Our ref: Blessed Carlo College, Moama (SSD-24262975)

Subject: Response to Submissions

The exhibition of the development application and environmental impact statement (EIS) for the Blessed Carlo College, Moama (SSD-24262975) ended on 07 Dec 2022.

The Department has also undertaken a preliminary assessment of the EIS and, in addition to the issues raised in agency submissions, requires the matters at **Attachment 1** be addressed in full.

3 SSSA_STAGE 3 WORKS
2 Scale 1 : 1000

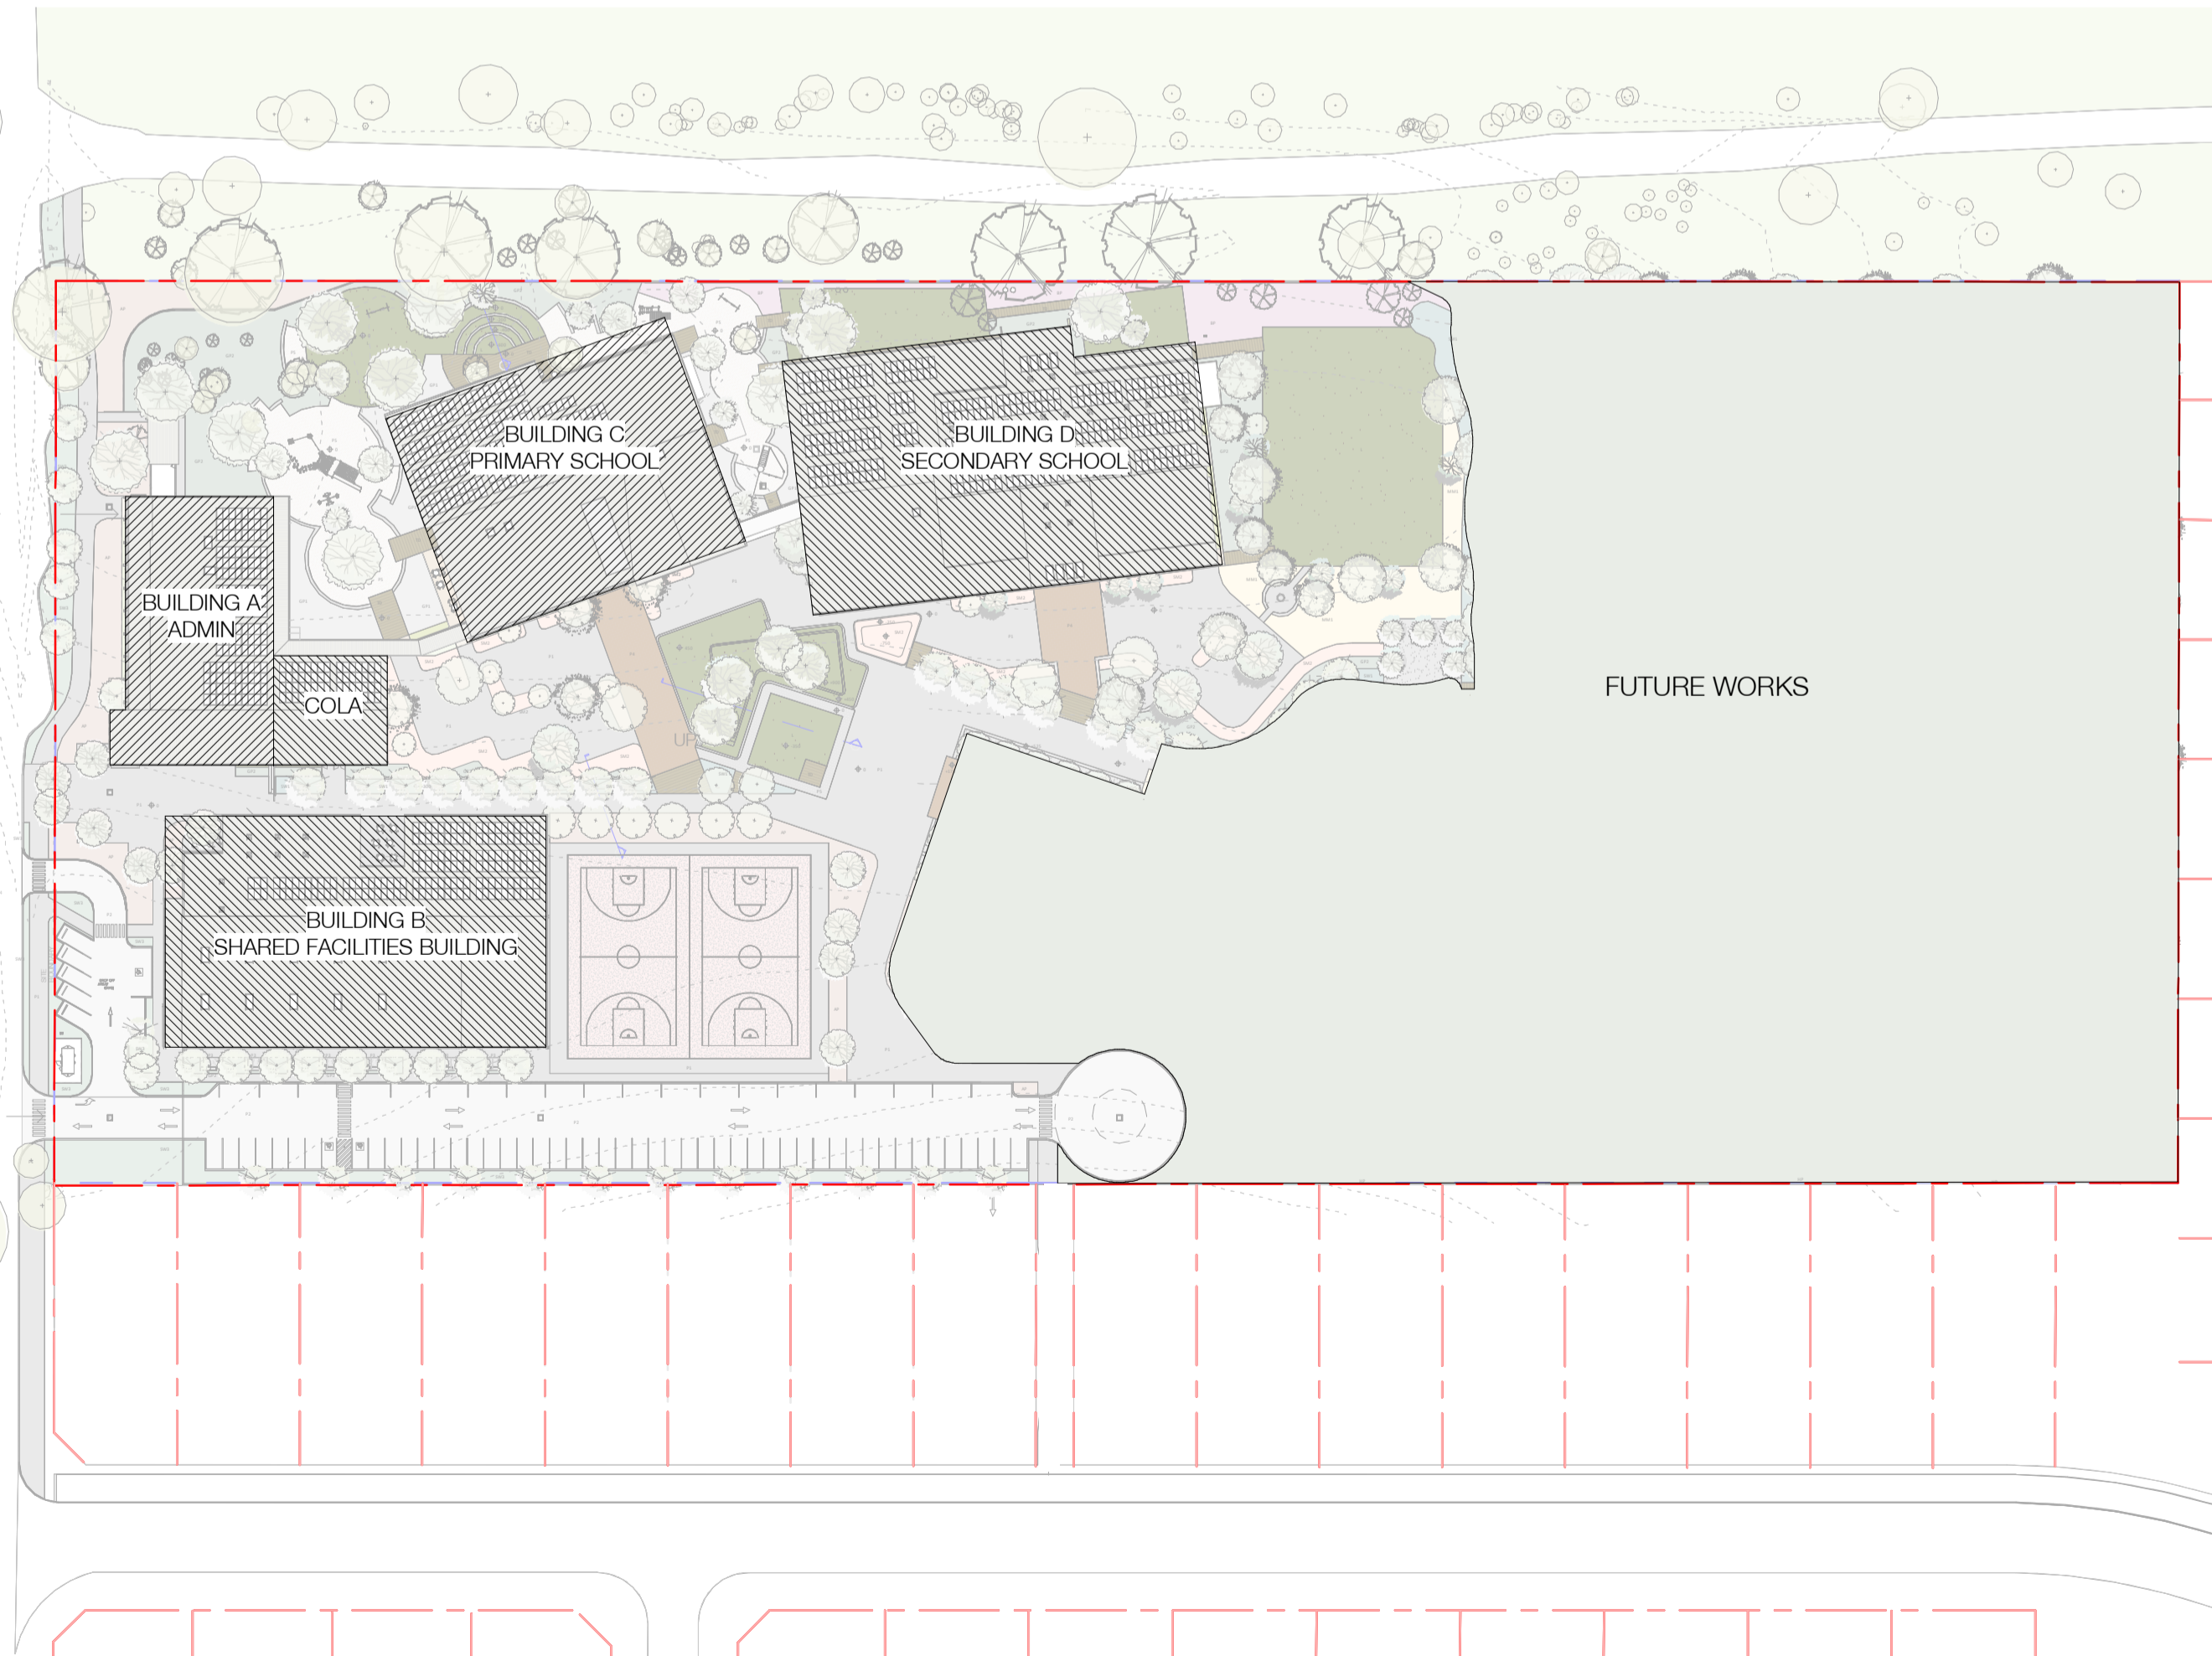
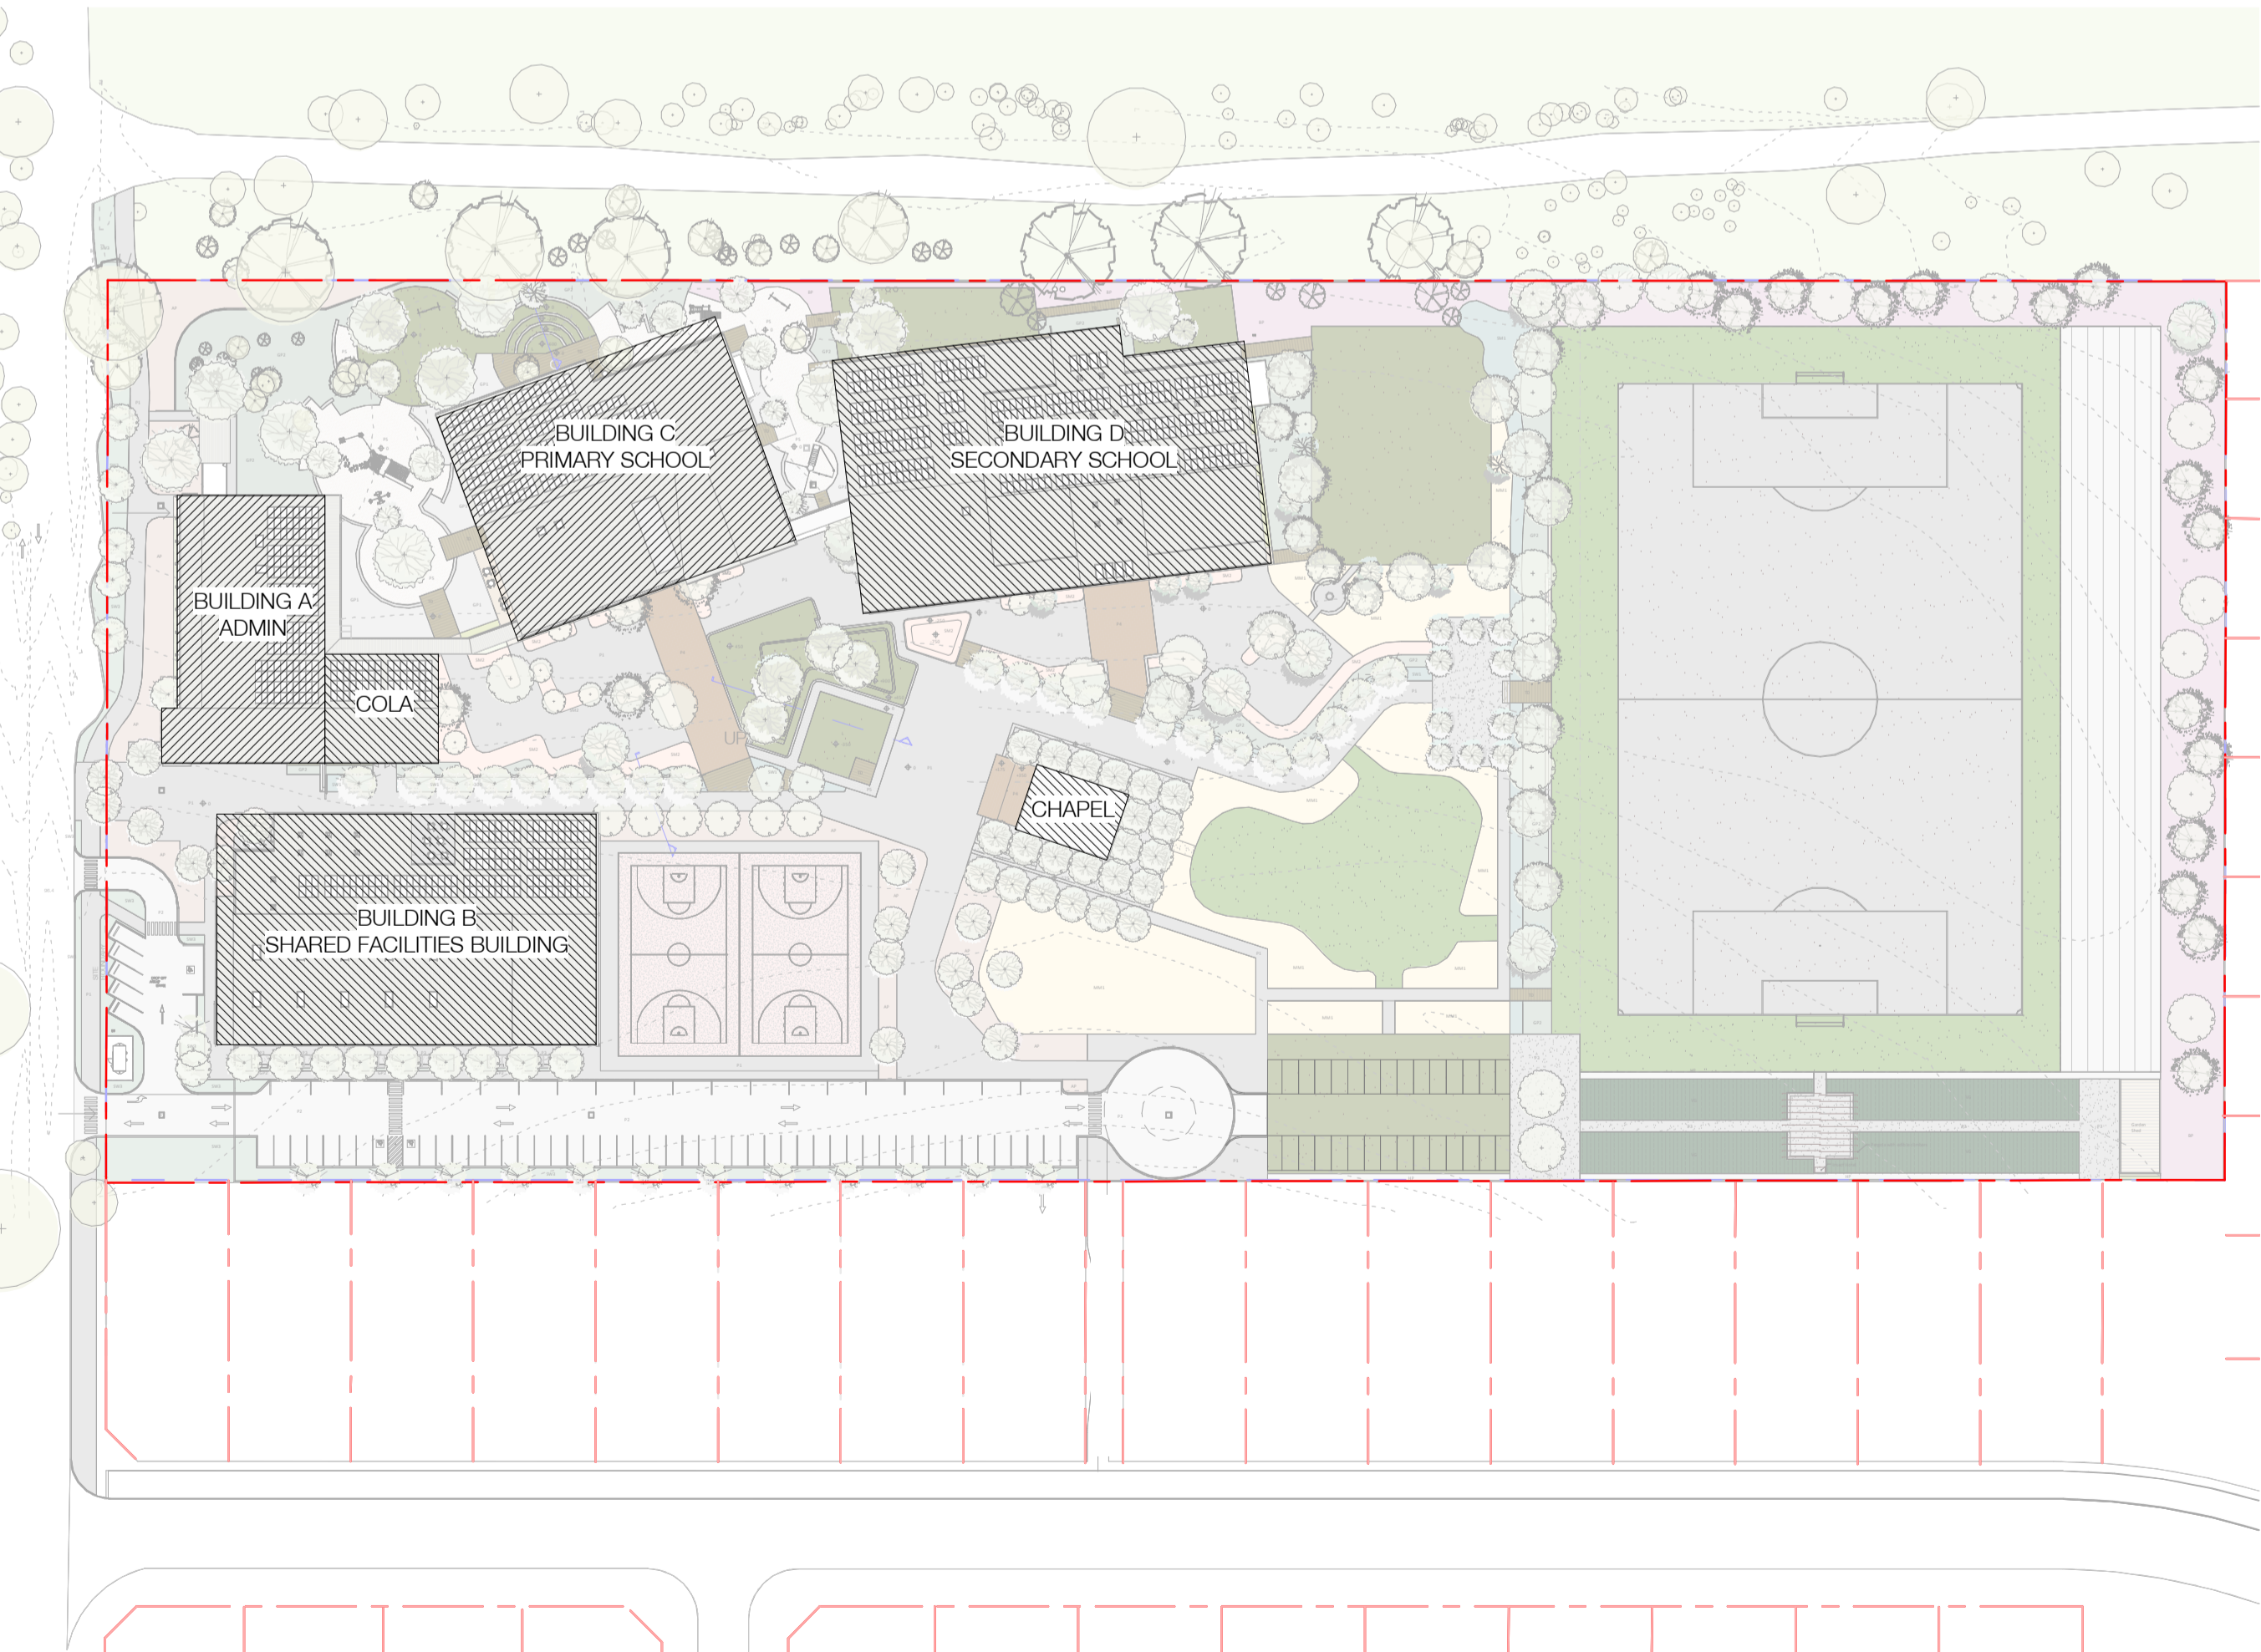
- The proposal would be delivered in four construction phases. In this regard the Department notes that the main open spaces and fields would be delivered in phase 4.
- Consequently, the Department requires you to provide details of the provision on open space and play spaces in each construction stage to demonstrate that at each operational phase the students have sufficient play space within the site complying with the 10sqm/student requirement of the Department of Education's Facilities Guidelines.
